DELEGATED HOUSEHOLDER DECISION

Item No.	Report of the Head of Development Management and Building Control	
Address:	4 ALMOND AVENUE ICKENHAM MIDDLESEX	
Development:	Erection of a single storey side & part single, part double storey rear extension and Enlargement of loft space to form habitable accommodation including 2 side dormers.	
LBH Ref Nos:	61421/APP/2025/2697	
Drawing Nos:	Pottle_4AlmondAve L.01 4463/01 L.02 L.03	
Date Plans received:	21-10-25	Date(s) of Amendments(s):
Date Application valid	28-10-25

ADDRESS 32 Milton Court Ickenham UB10 8ND		
DRAWING TITLE Elevations proposed		
PROPOSAL Rear part double extension side single storey extension front porch, garage conversion Loft conversion		
SCALE 1:100	DATE May 25	REV
DRAWING NUMBER L.04

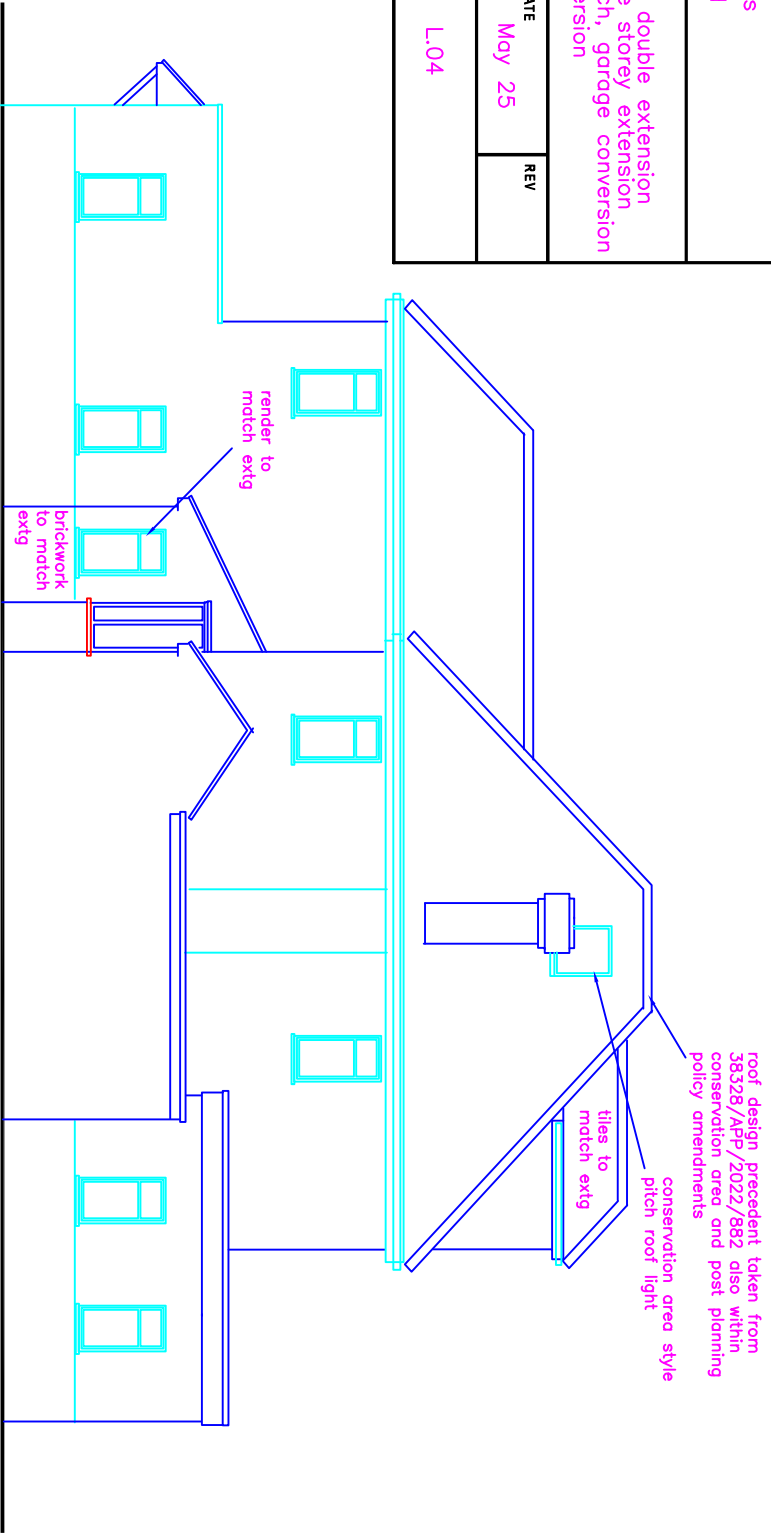
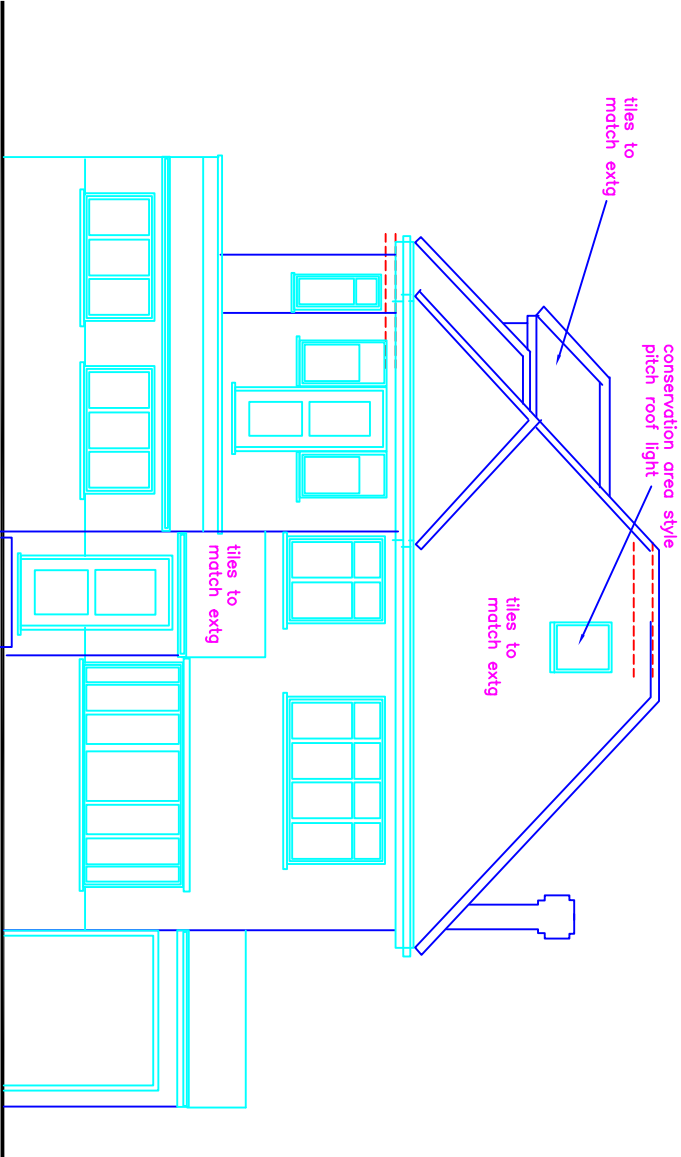
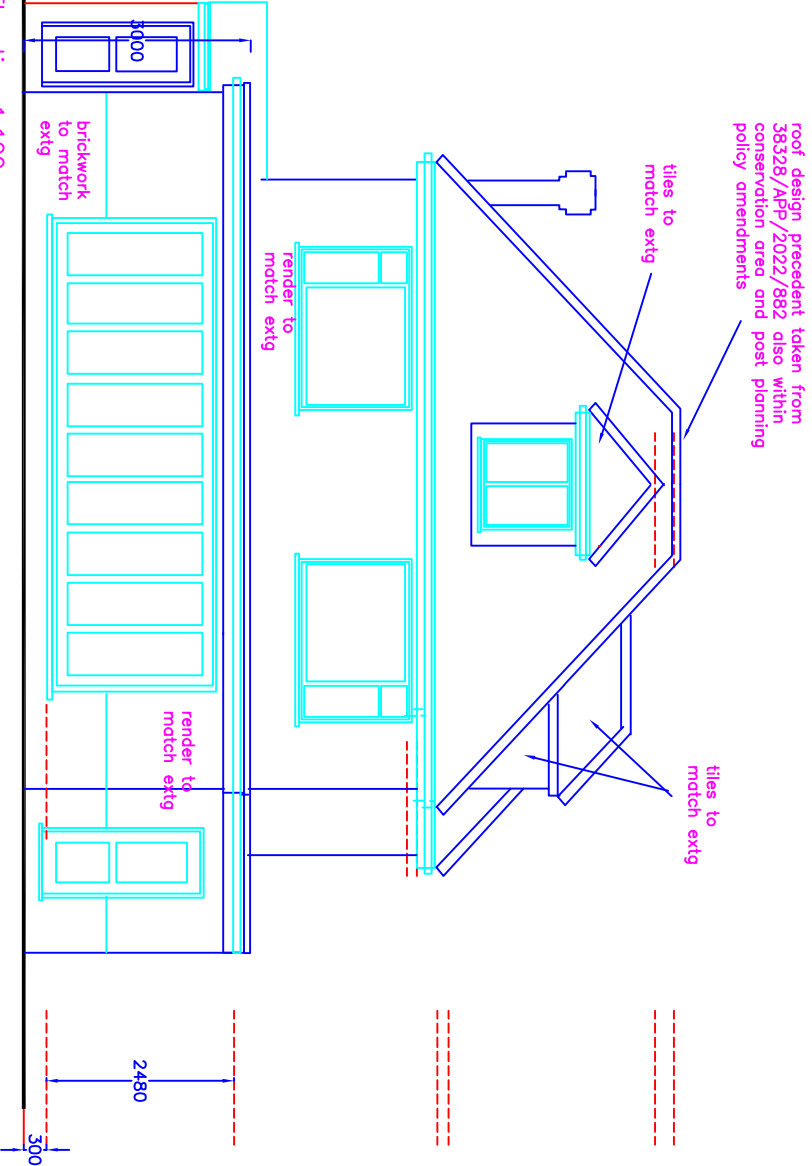
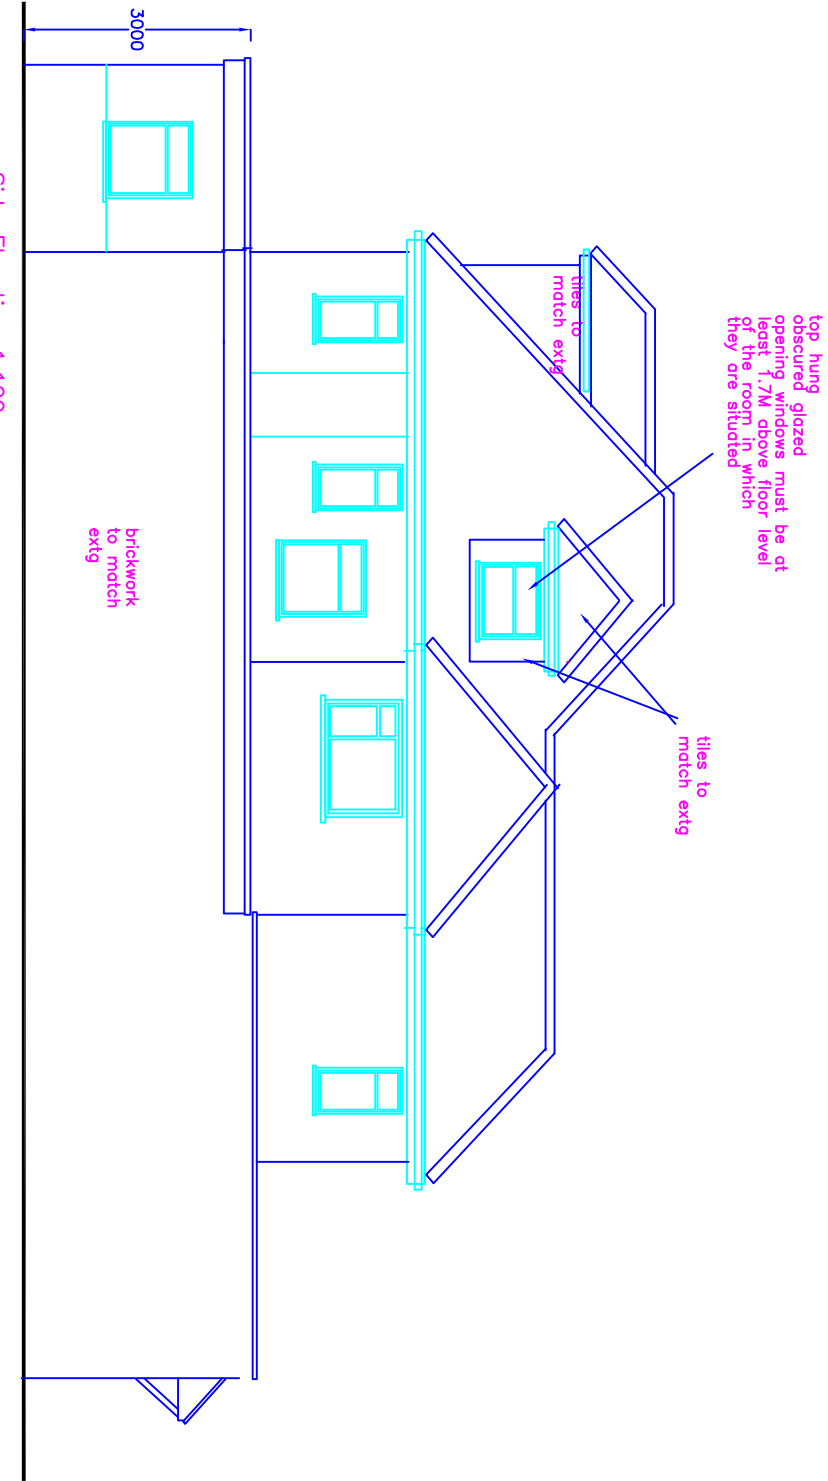
The scheme proposes two large side dormers which would measure approximately, 2.75m in width when seen from the front elevation, 2.5m in height and 1.93m in depth. Whilst the principle of additional accommodation within the roofspace may be acceptable in some circumstances, the Council's design approach within conservation areas seeks to ensure that additions do not erode the simplicity and integrity of the original roof form. In this instance, the side dormers would disrupt the continuity of roof slopes and introduce visually intrusive roof alterations.

Whilst the side dormers, would be set lower than that of the existing roof profile, the size, density and visibility, given the formation of the roof profile of the host dwelling; the dormers add significant visual impact and bulk of the development.

The two side dormers would result in an unacceptable cumulative impact on the roof form. The dormers would interrupt the previously unbroken side roof planes and would appear as discordant additions when viewed within the street scene, including oblique views along the road.

The proposed development, by reason of the introduction of two side dormer extensions, would result in an unacceptable and visually intrusive alteration to the original roof form of the host dwelling. The dormers would interrupt the previously unbroken side roof slopes through their cumulative impact which would erode the simple and coherent roofscape of this group of mid-20th century properties, thereby appearing as discordant additions within the street scene. Overall, the development would fail to preserve the character and appearance of Ickenham Village Conservation Area causing less than substantial harm to the conservation area without any notable public benefit. Therefore, the proposal would be contrary to Policy D3 of The London Plan (2021), Policy BE1 of the Hillingdon Local Plan: Part One - Strategic Policies and Policies DMHB 4, DMHB11, DMHB12 and DMHD1 of the Hillingdon Local Plan - Part Two (2020).

FOR PLANNING PURPOSES ONLY		
ADDRESS		
32 Milton Court Ickenham UB10 8ND		
DRAWING TITLE		
Plans proposed		
PROPOSAL		
Rear part double extension side single storey extension Front porch, garage conversion Loft conversion		
SCALE	DATE	REV
1:100	May 25	
DRAWING NUMBER		
L.02

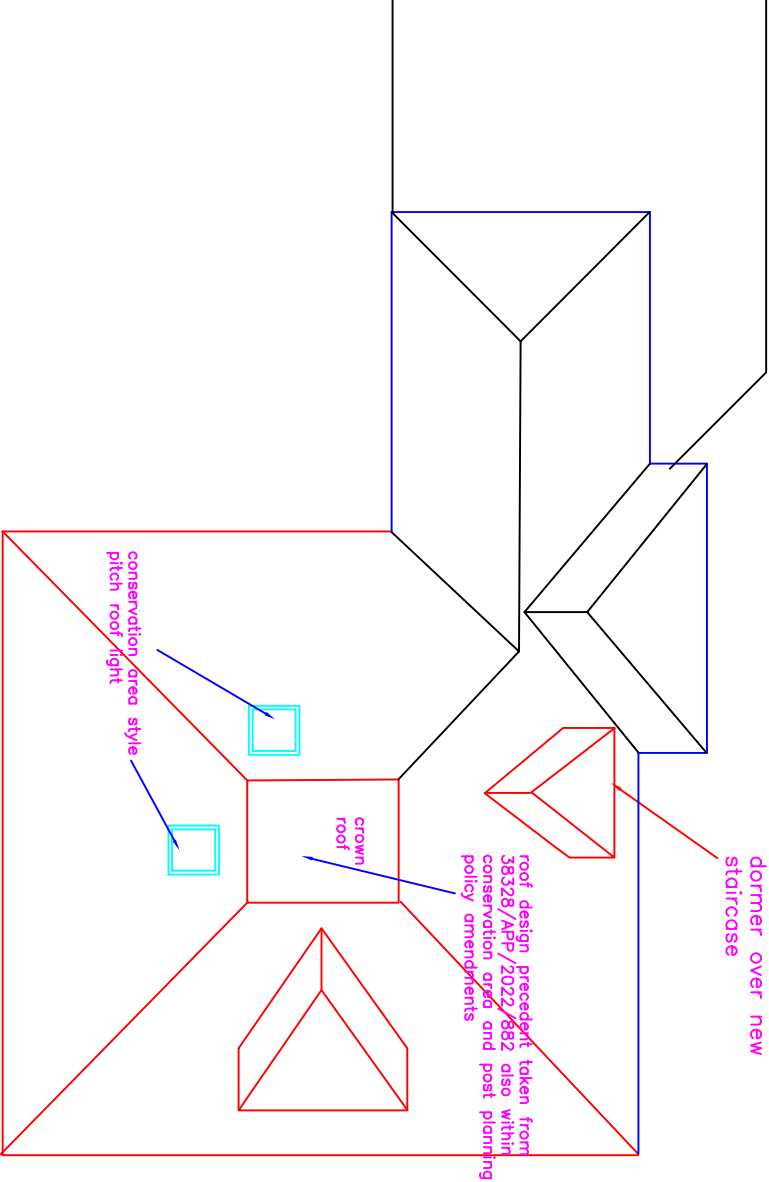
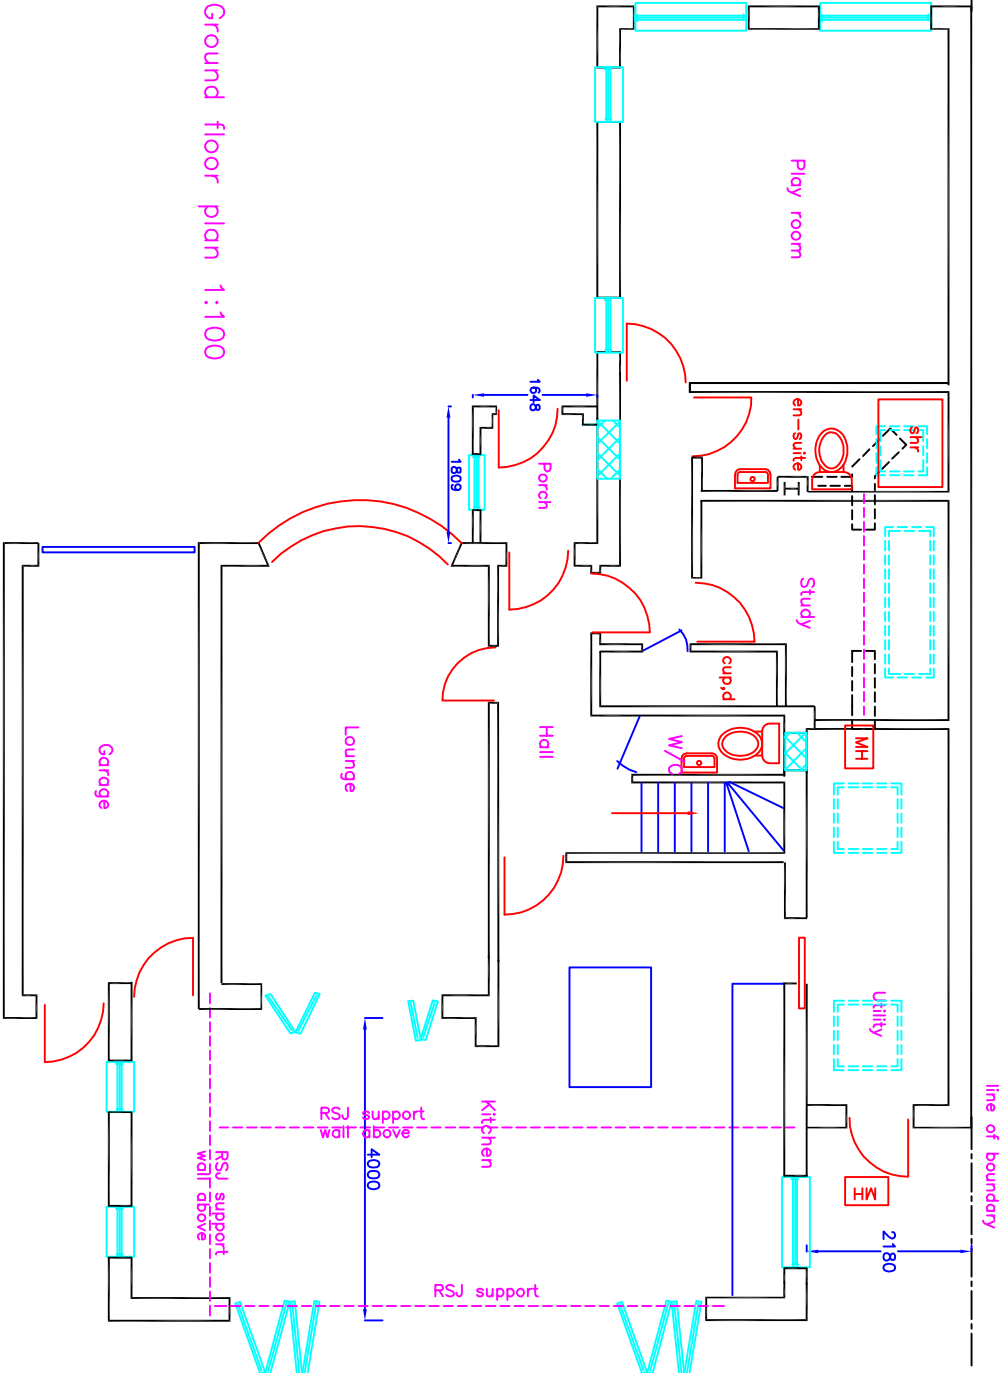
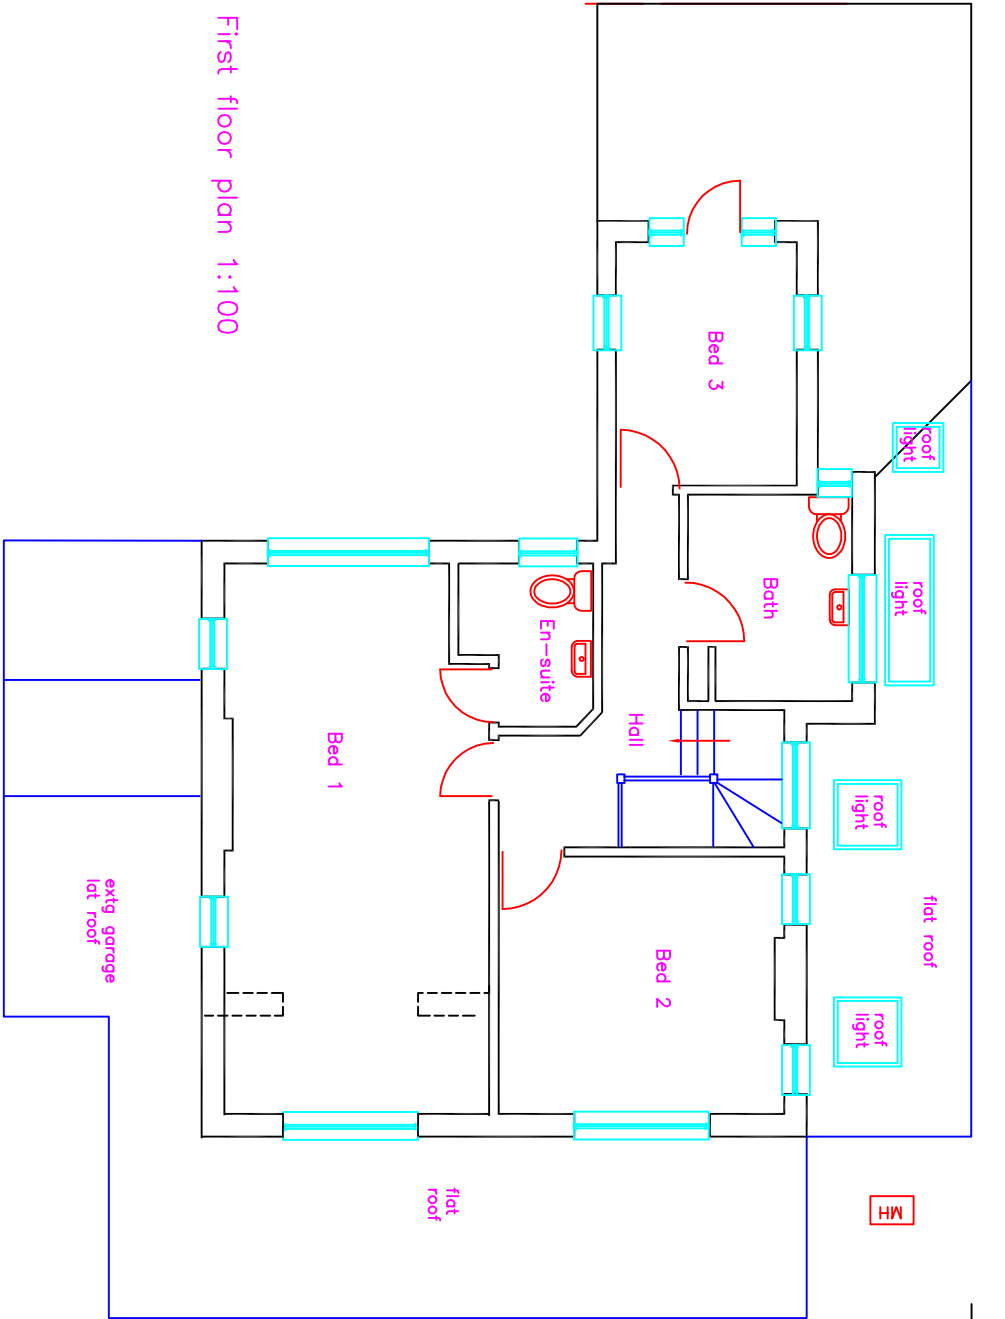
The scheme proposed a side extension which would be located on the west on the property measuring approximately, 1.8m in width, 12m in depth (joining the rear to form a wrap around on the ground floor) and 3.34m in height. This element would sit approx 0.2m from the shared boundary with 5 Almond Avenue. The roof would include 5 conservation style rooflights. Number 5 Almond Avenue was previously given planning permission for a similar development in 2017 (36448/APP/2017/3829) which was renewed recently under planning permission (61421/APP/2024/2854). Given this, alongside the established principle of such extension on the street, this element is acceptable and compliant with DMHD 1.

The single storey element measures approximately 8.19m in width, 4m in depth and 3.84m in height. This element is compliant with Policy DMHD1 whereby rear extensions on detached dwellings allow a depth of 4m. As this overall design is in line with the recently approved scheme, there is no objection from the Conservation Officer. This overall design follows on from the Inspector's finding under Appeal decision APP/R5510/D/21/3270366 whereby the Inspectorate concluded that the rear extension would complement the features of the existing house in regard to its roof design.

The two storey rear element would measure approximately, 3m in depth on the boundary to the E3E2SWX/8*/89°ast, 4.16m on the West and 6.44m in width, 6.95m in height with a pitched roof and sit below the original height of the roof profile. The double storey side element would be set in by approx. 2m from the side boundary to the West (No 5 Almond Av.). There is no information regarding the 45 degree line and how this would impact the neighbouring property on the East that has been submitted the application. However, given the modest increase in depth of 3m on the building line combined with the lack of visibility from the street profile, this element is acceptable.
